Please ask for: Ms Iqraa Malik
Email: iqraa.malik@terraquest.co.uk
Telephone: 01212341390
Our Ref: LU/190/20/HH
Your Ref:
Date: 23rd July 2020

Application for Planning Permission for Works or Extension to a Dwelling

Development: Front porch extension to include new WC cloakroom
Location: 15 The Winter Knoll Littlehampton BN17 6NB

SITE PLAN 1:500 @ A4

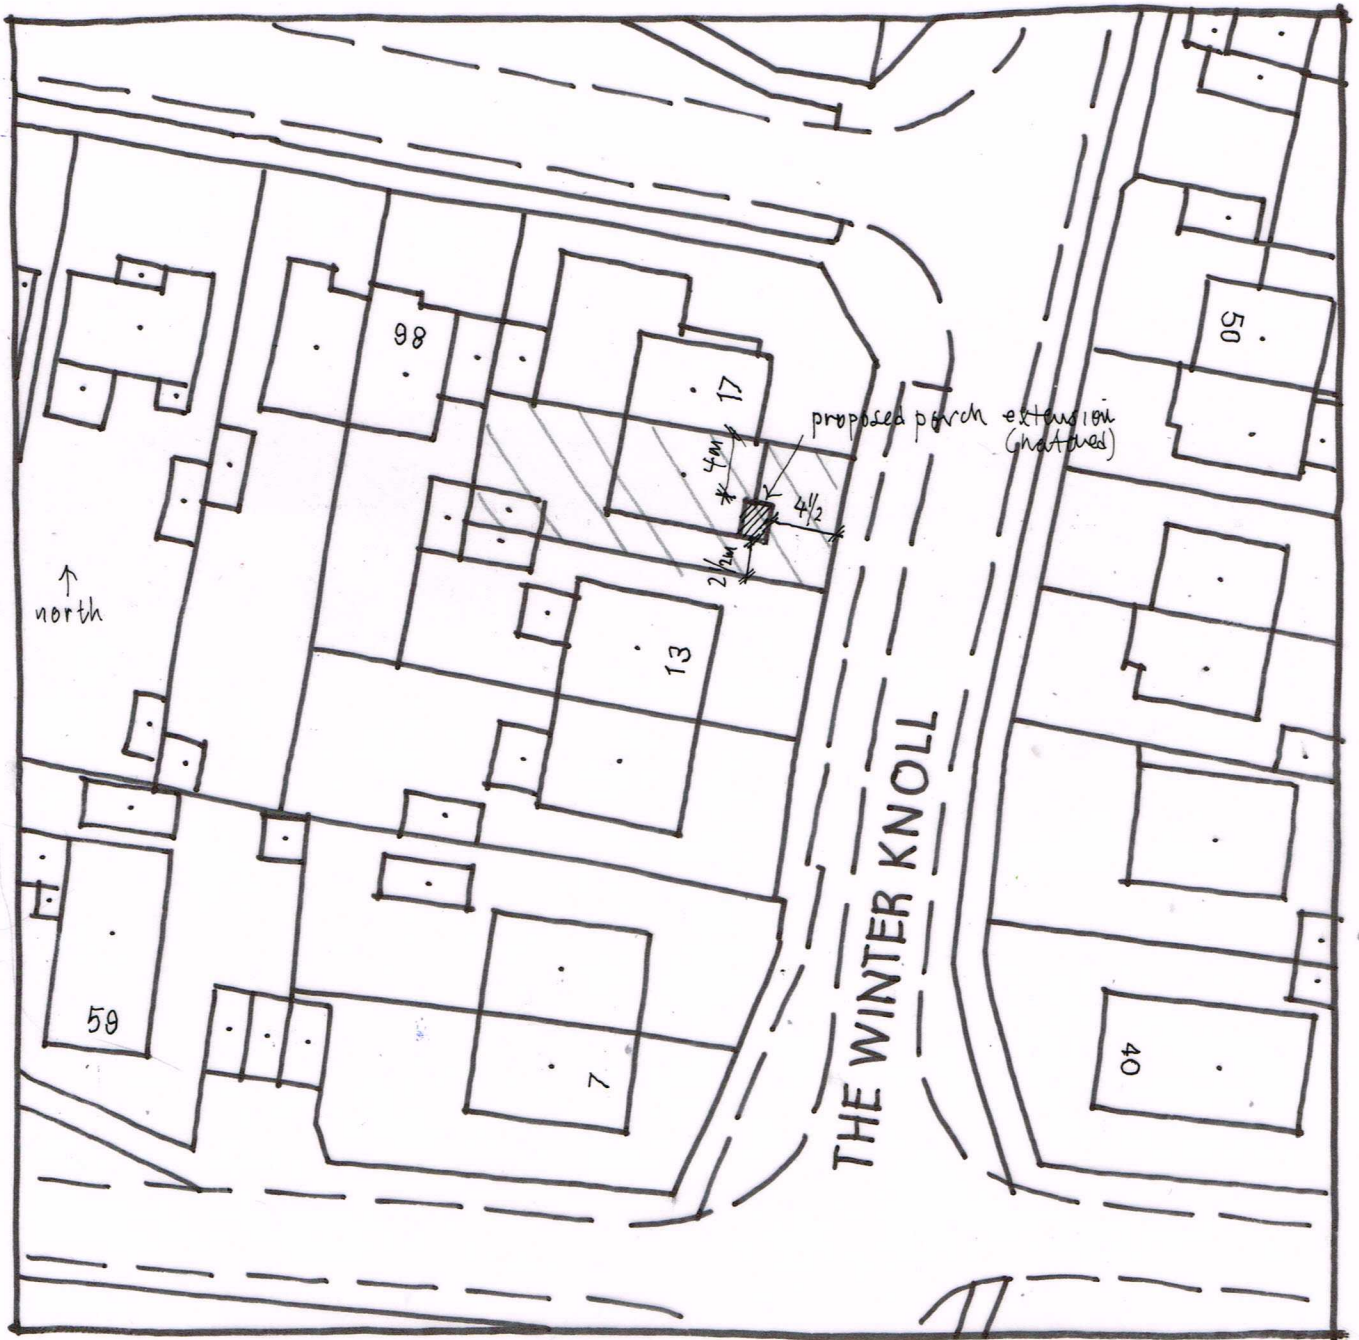
Block Plan

You are required to have dimensions from the proposed extension(s) to all site boundaries. Please amend.
